# CITY OF ALBUQUERQUE

**Re: Chase Bank – Indian School Road**  
**6670 Indian School Road NE**  
**Traffic Circulation Layout**  
Architect's Stamp 06-30-2021 (J18-D001C)

Based upon the information provided in your submittal received 07-07-2021, the above referenced plan cannot be approved for Building Permit until the following comments are addressed:

TRAFFIC CIRCULATION PLAN

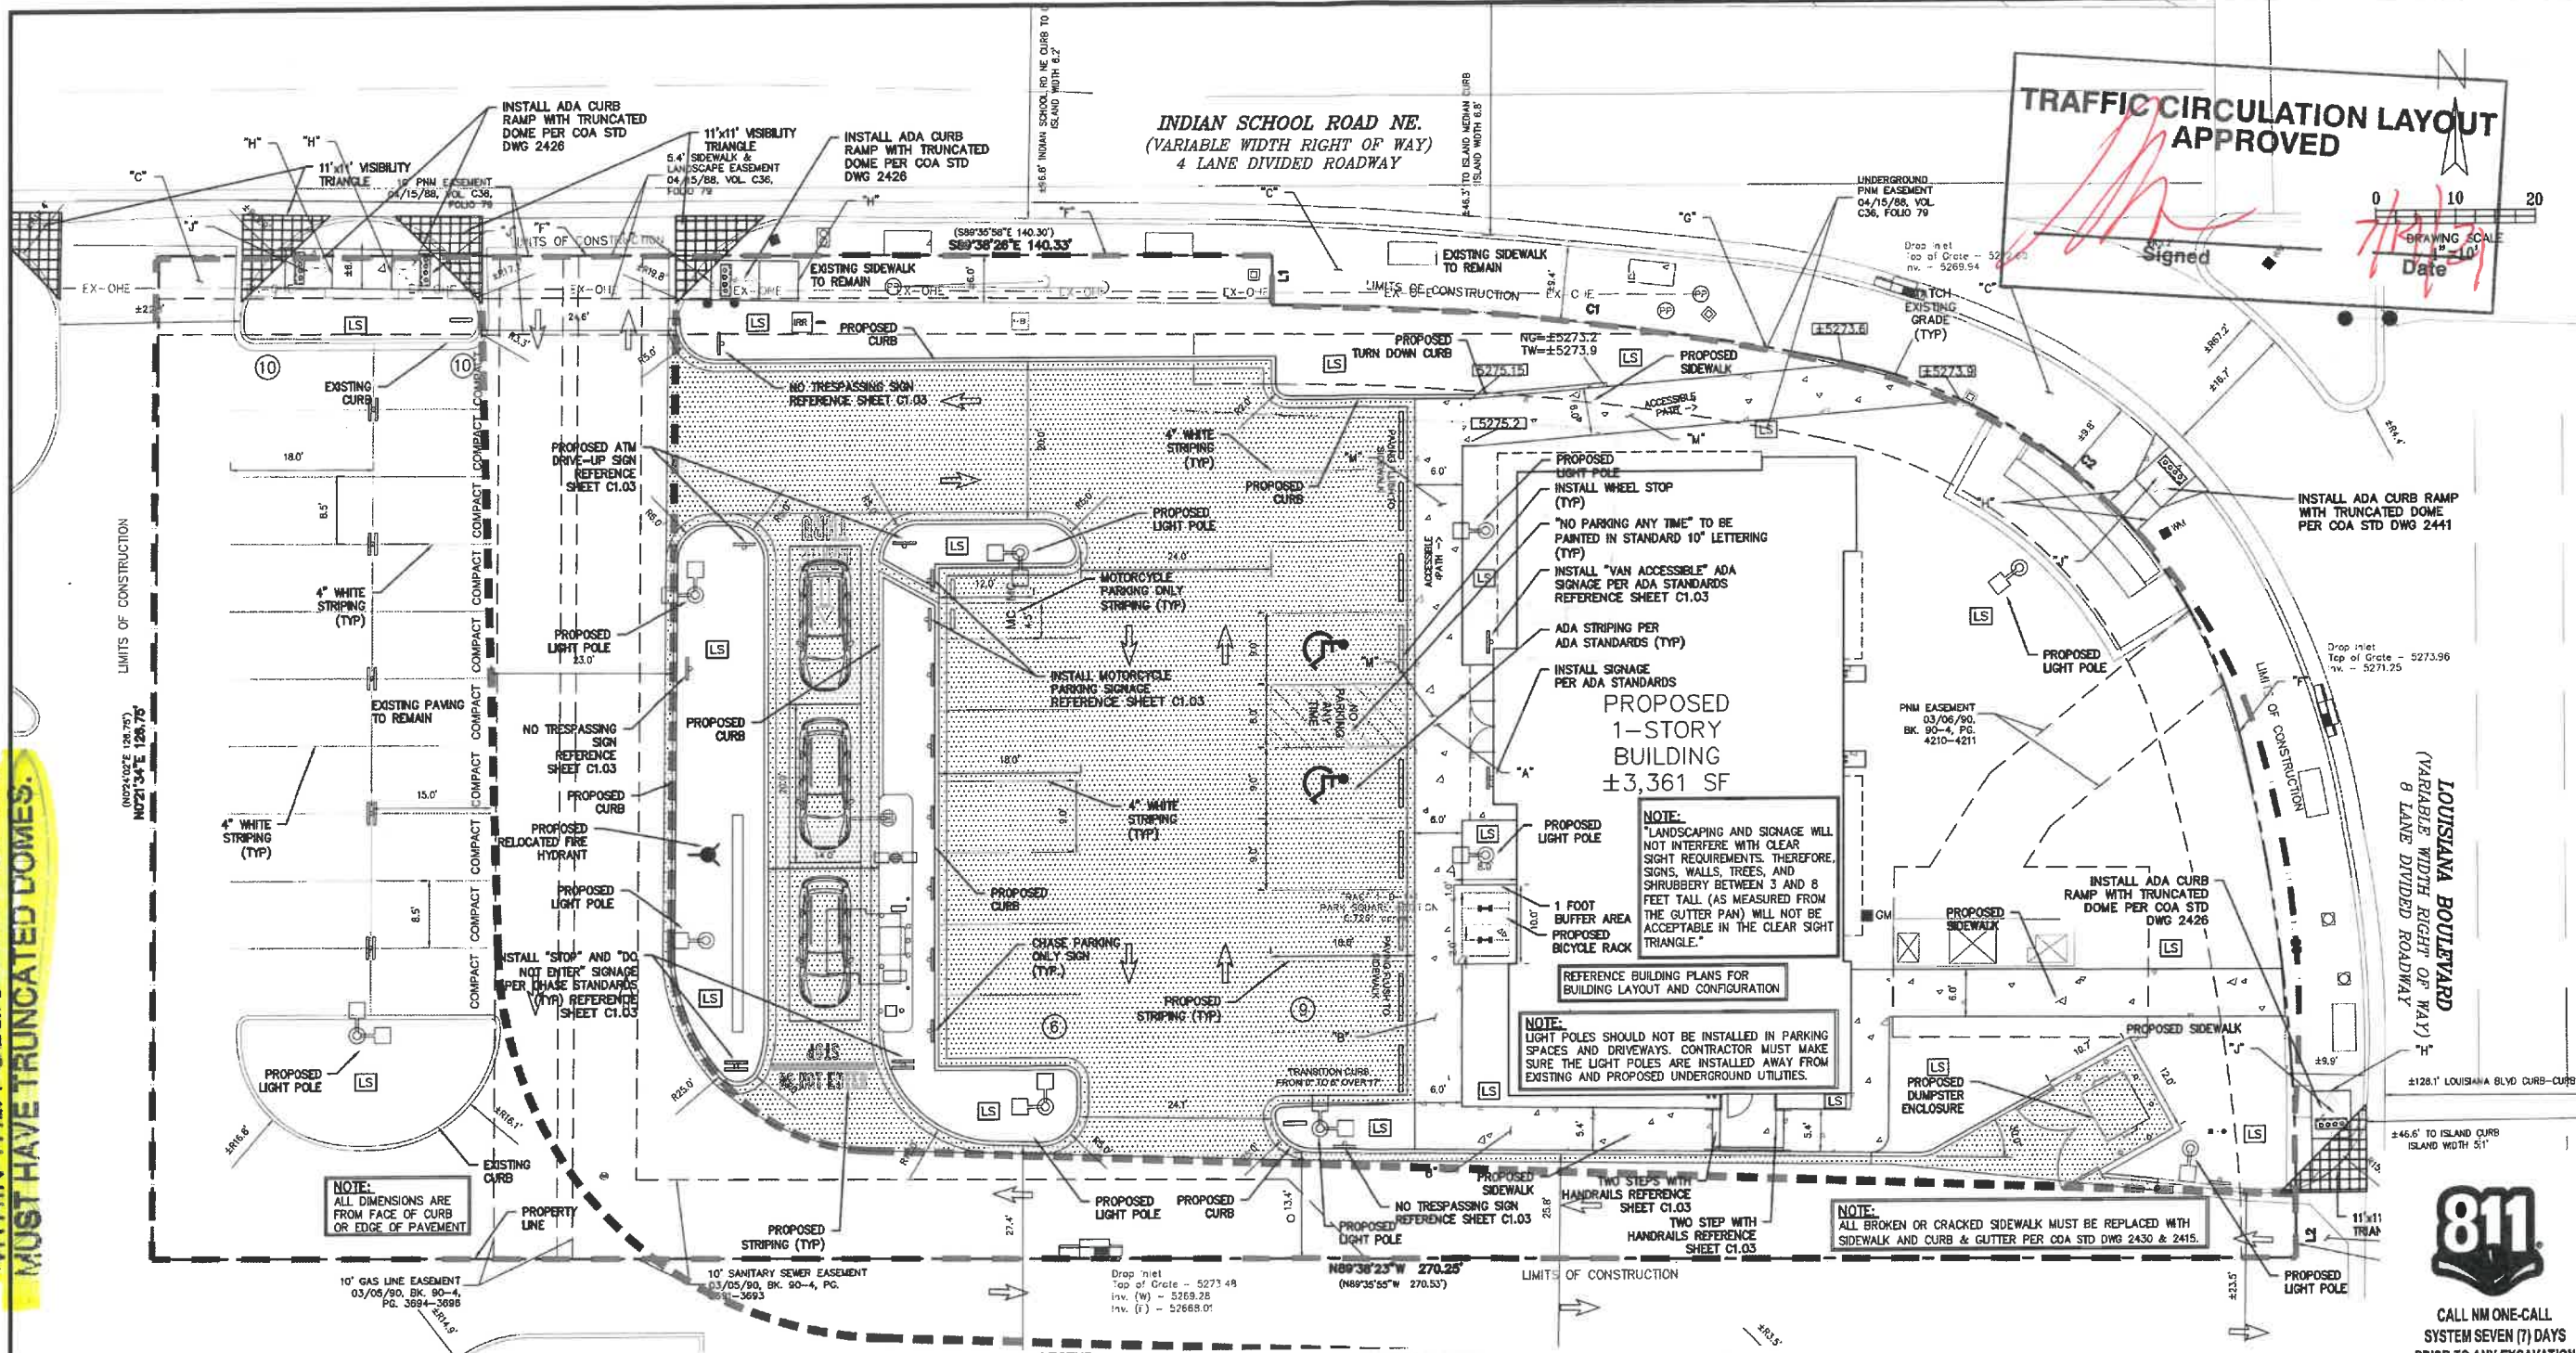
3. The new location of the Solid Waste enclosure appears to impact 3 parking stalls that have been removed. Please provide a new parking stall calculation to substantiate the loss of the stall wouldn't impact the total required stall and/or provide a statement as to this concern.

4. Add a note stating "All broken or cracked sidewalk must be replaced with sidewalk and curb & gutter." A build note must be provided referring to the appropriate City Standard drawing.
